Technical Memorandum

Subject: *989 Somerset Street Residential Development – Transportation Addendum No. 2*

Response to City of Ottawa Comments

Re: 989 Somerset Street W
TIA Strategy report– Response to City Comments

DRAWING TITLE:
 SITE PLAN

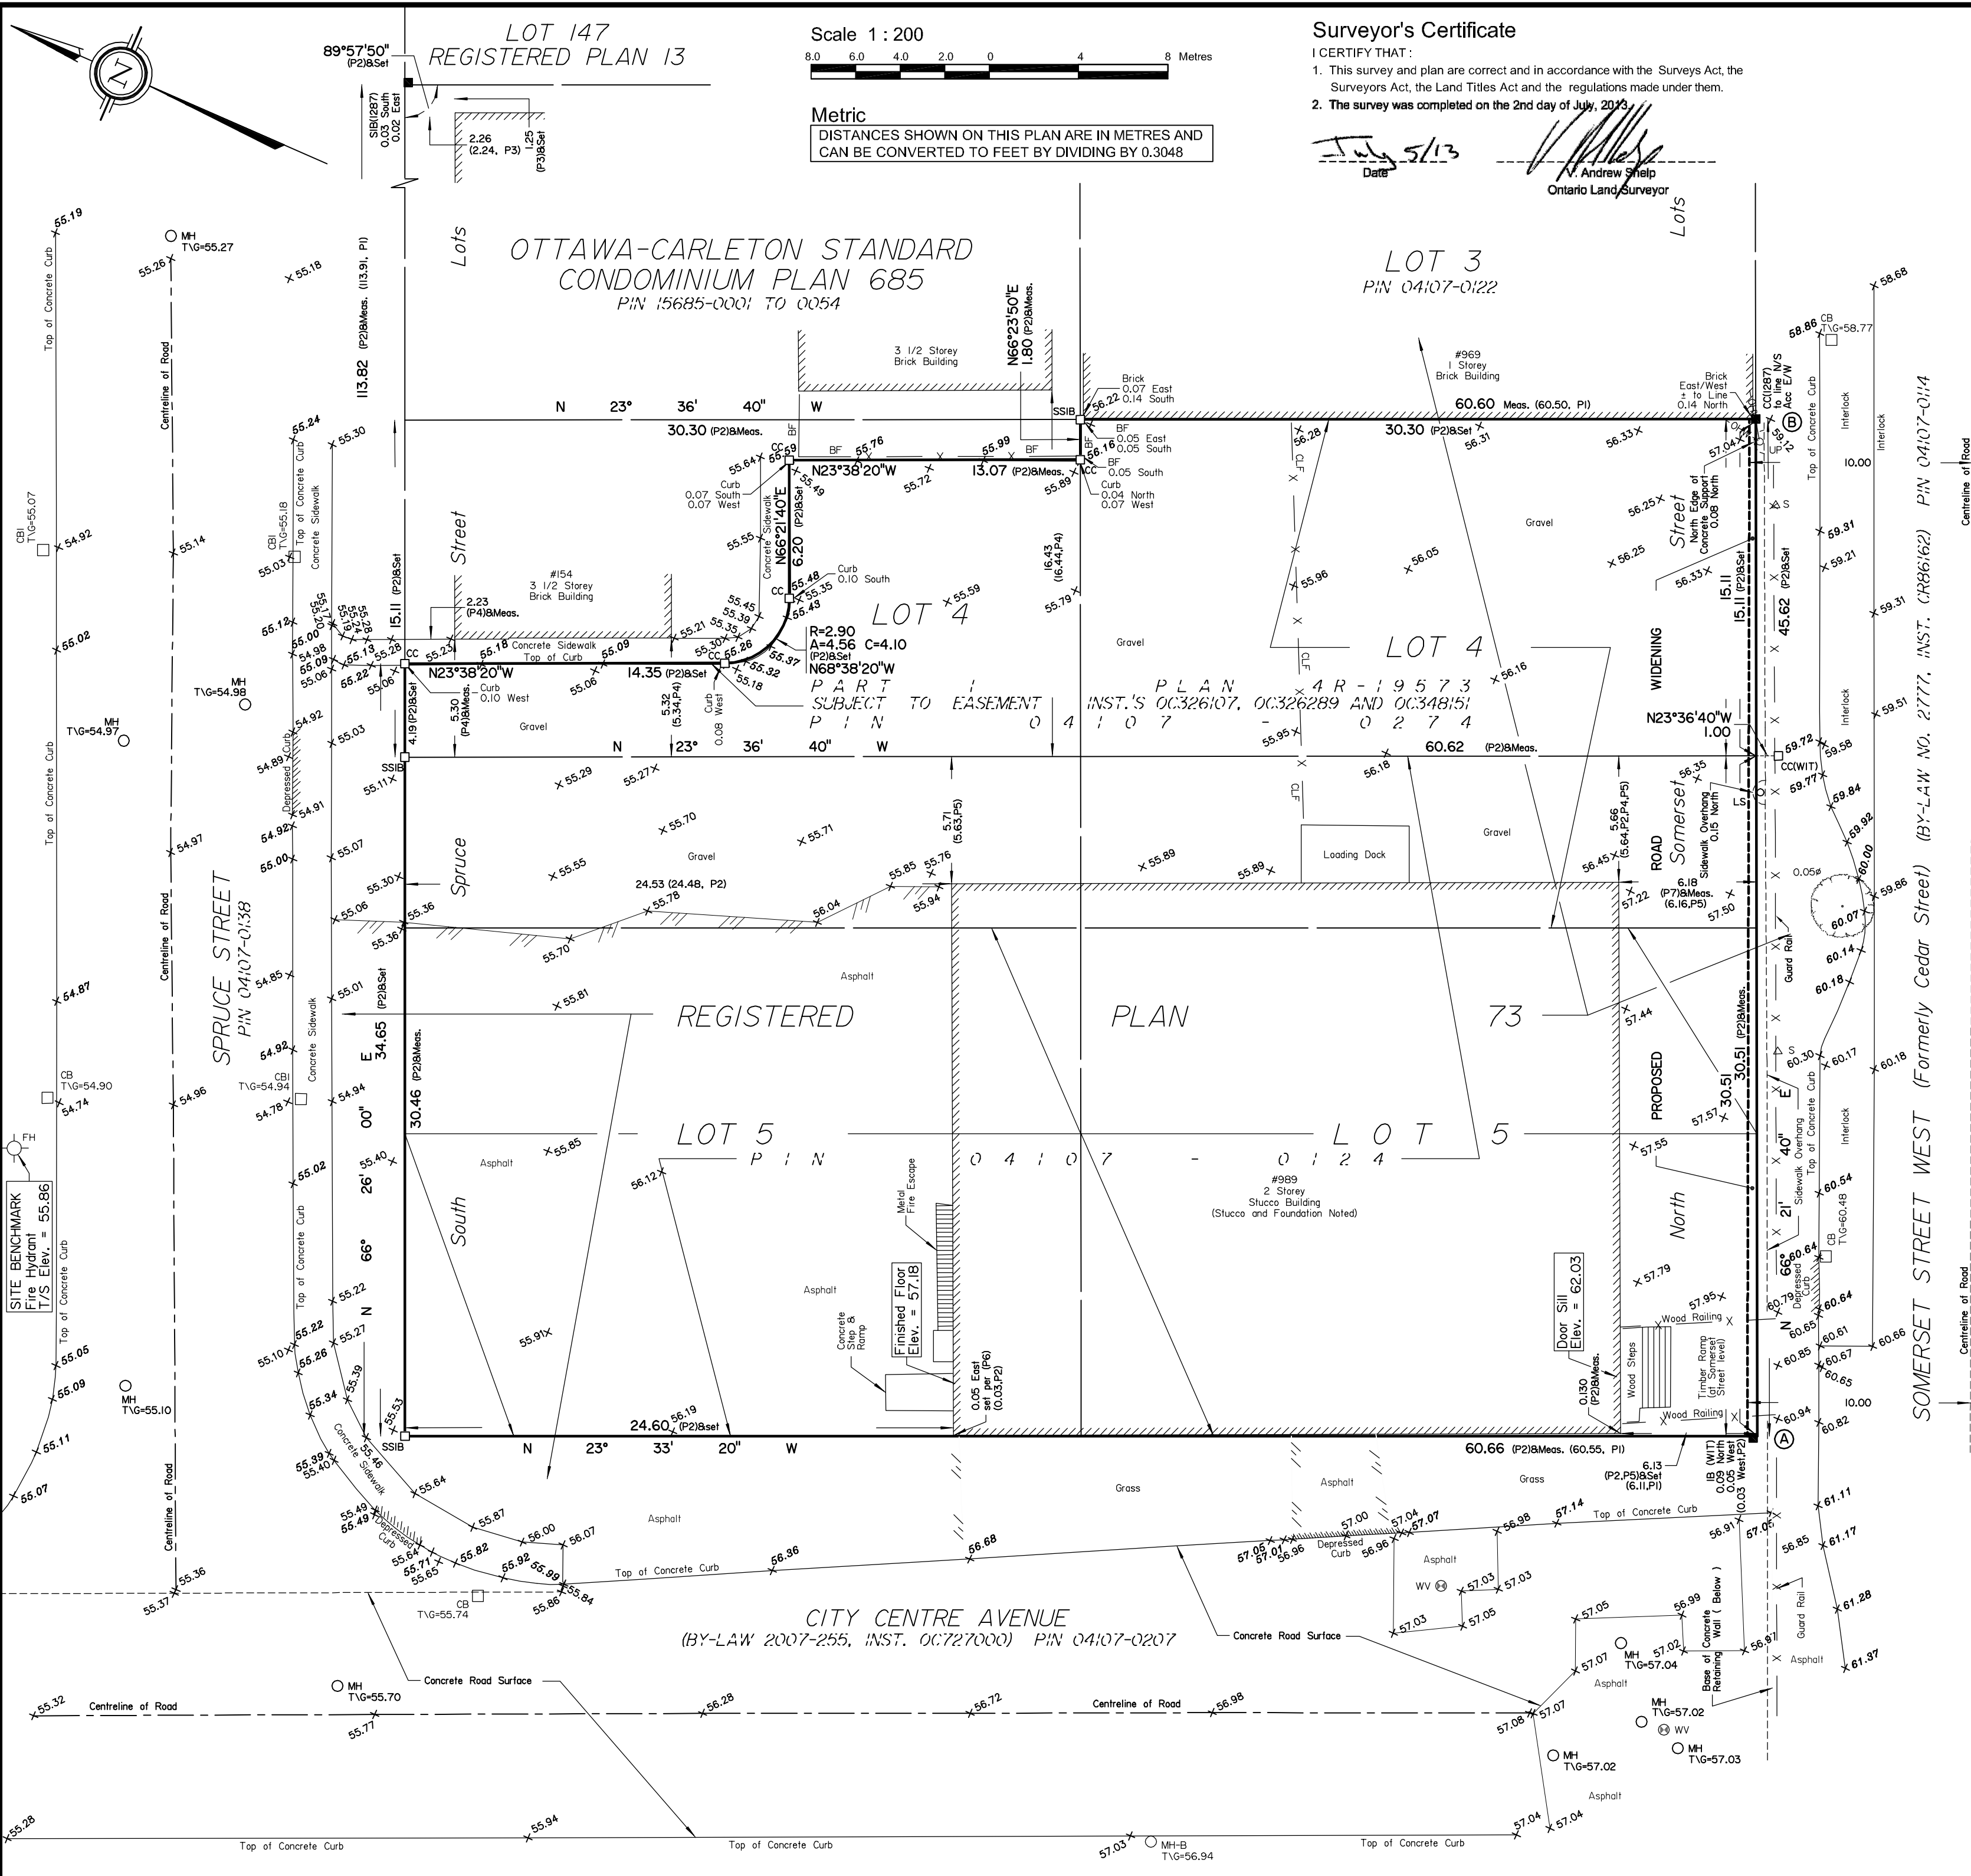
- The at grade parking lot access should be 6.7 m wide as per the Zoning Bylaw Section 107. If the proposed access is to remain its current width, an exemption is required.

The access throat width has been maintained at approximate 6.1 meters and the drive aisle width has been increased to 6.9 meters. No exemption is required.
